Tees CCPP Project

The Tees Combined Cycle Power Plant Project

Applicant's Comments on the Environment Agency's Responses to the Examiner's Written Questions

Applicant: Sembcorp Utilities (UK) Limited
Date: May 2018

Figure 1 - Tees CCPP High Level Layout

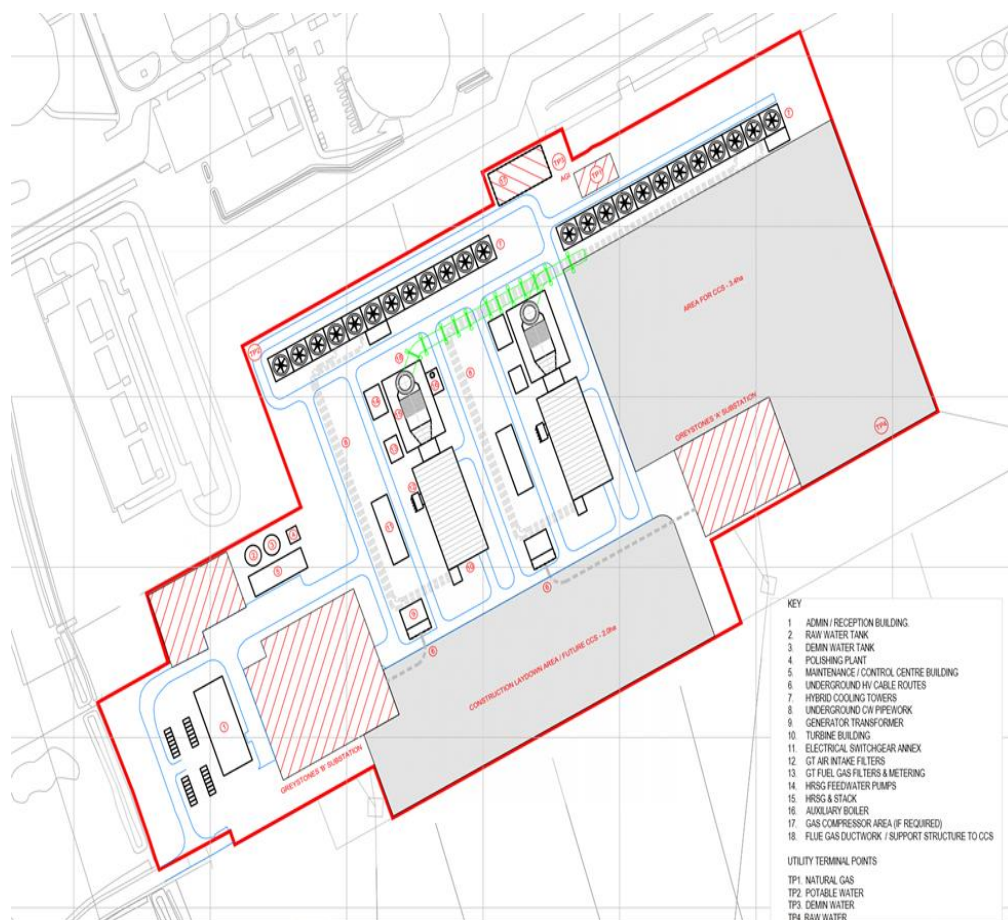
Question No. (Ref. No.)	ExA's question	EA's response	Applicant's comments
	<p>What further reassurance can be provided that this area would be adequate for CCR?</p>	<p>The Environment Agency cannot comment on the proposed CCR footprint of 5.4 ha without additional evidence that the CCP will fit into the space allocated. The information required in Annex C of the DECC CCR (2009) guidance is therefore required. Please refer to the Carbon Capture and Storage Section in our written representations letter.</p> <p>The DECC Carbon Capture Readiness 2009 guidance states: <i>Applicants should submit the required assessments demonstrating CCR as part of their initial Section 36 consent application with its supporting documentation. The assessments should not be considered supplementary information which can be submitted at a later stage. Together with the rest of the Section 36 application material, these assessments will be public documents. This guidance also explains the level of information which applicants can reasonably be asked to submit in the demonstration of CCR when applying for Section 36 consent.</i></p> <p>The information required by Annex C, DECC CCR (2009) should be submitted at the DCO application stage to feed into decisions about plot size, location and orientation.</p> <p>An approach taken at another plant involved engaging the services of Florin and Fennel, to review their technical CCR proposals and to write a report confirming whether they considered the space available and the design was feasible. The EA accepted this report as part of the DCO consultation process. This approach should be considered by the applicant.</p>	<p>Please refer to the Applicant's Response to Examining Authority's Written Questions (Application Document Ref: 8.6) submitted at Deadline 2 of the Examination.</p>
